# CITY OF PORTLAND, MAINE

## PLANNING BOARD

January 25, 2013

Project Name: New Yard at Canal Landing  
Project ID: #2012-575  
Address: 40 West Commercial Street  
CBL: 59-A-1,2,3,4,5,6,7,8,9,10,11,12  
Applicant: New yard, LLC  
Planner: Bill Needelman, Senior Planner

DRAWN: CMW DATE: APR 2012  
 DESIGNED: RJW SCALE: 1" = 50'  
 CHECKED: SRB JOB NO. 3091  
 FILE NAME: 3091-SITE LAYOUT  
 SHEET: C-2.1

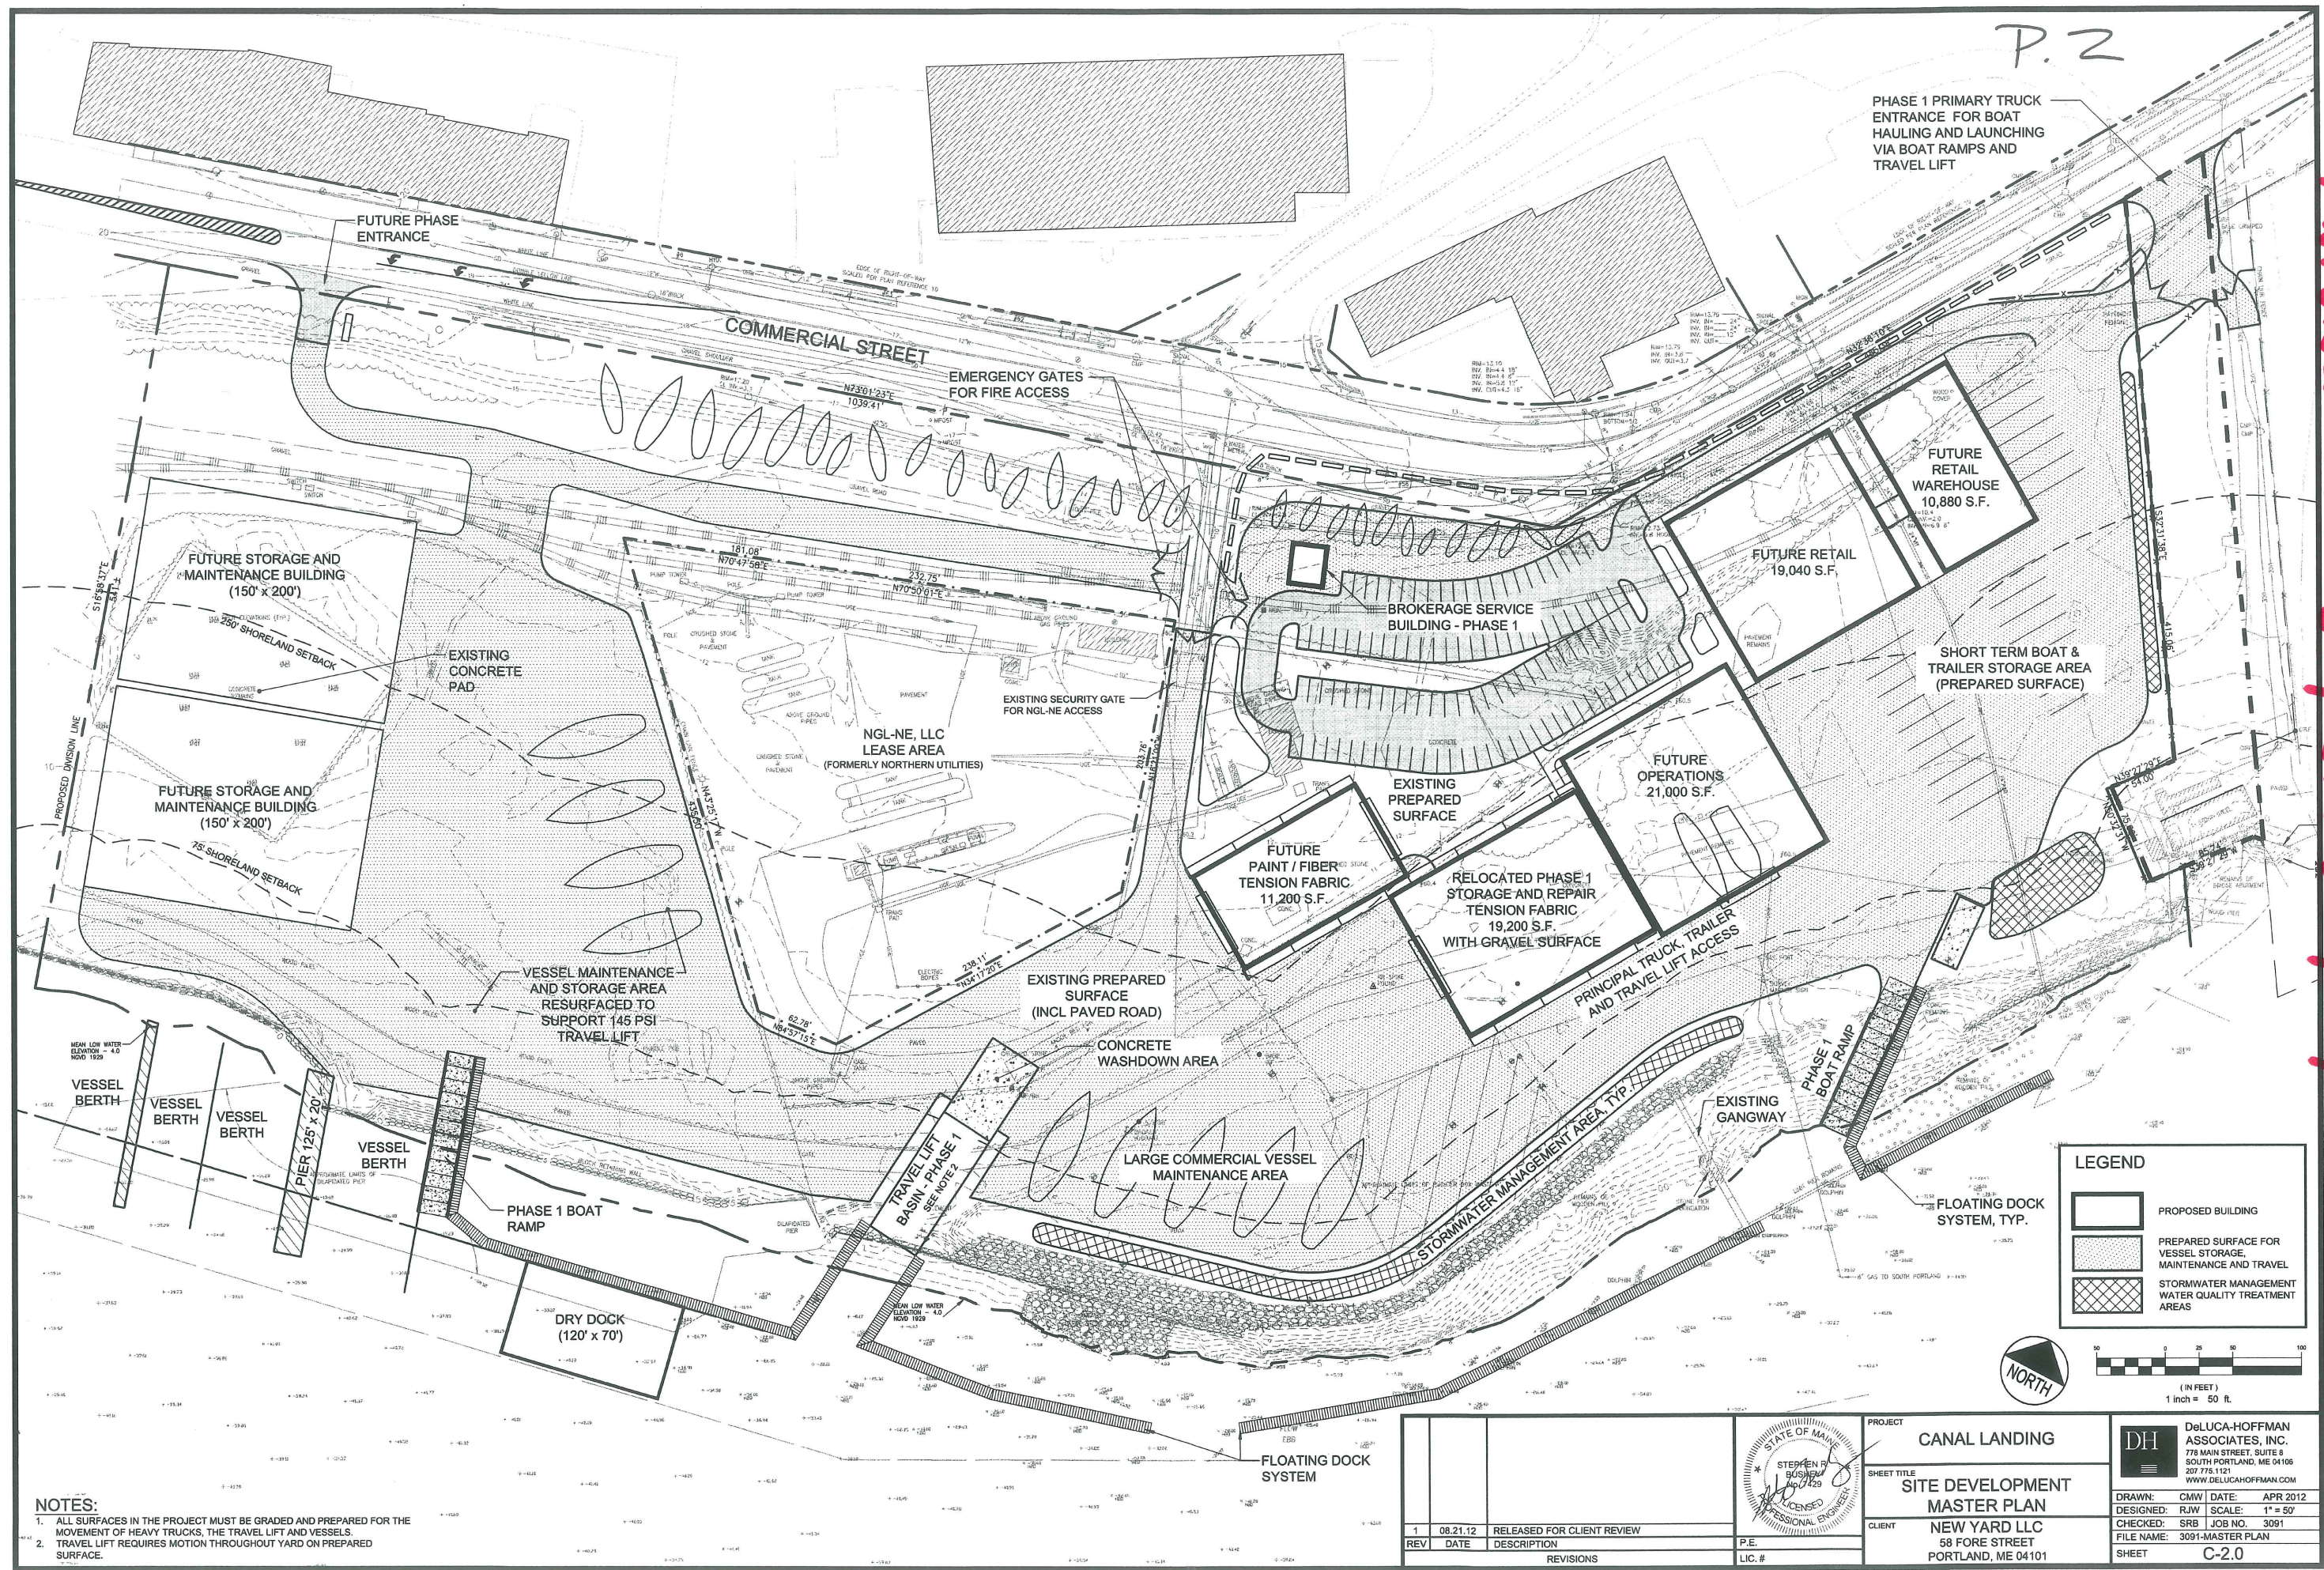
- iii. Combined Sewer Overflow Easement: that prior to issuance of a building permit, the applicant provides a 30 foot wide easement to the City for the combined sewer overflow line crossing the property from West Commercial Street to the Fore River as shown on the Deluca Hoffaman Site Development Plan, C-2.1, revision 4, dated 12-5-12.*
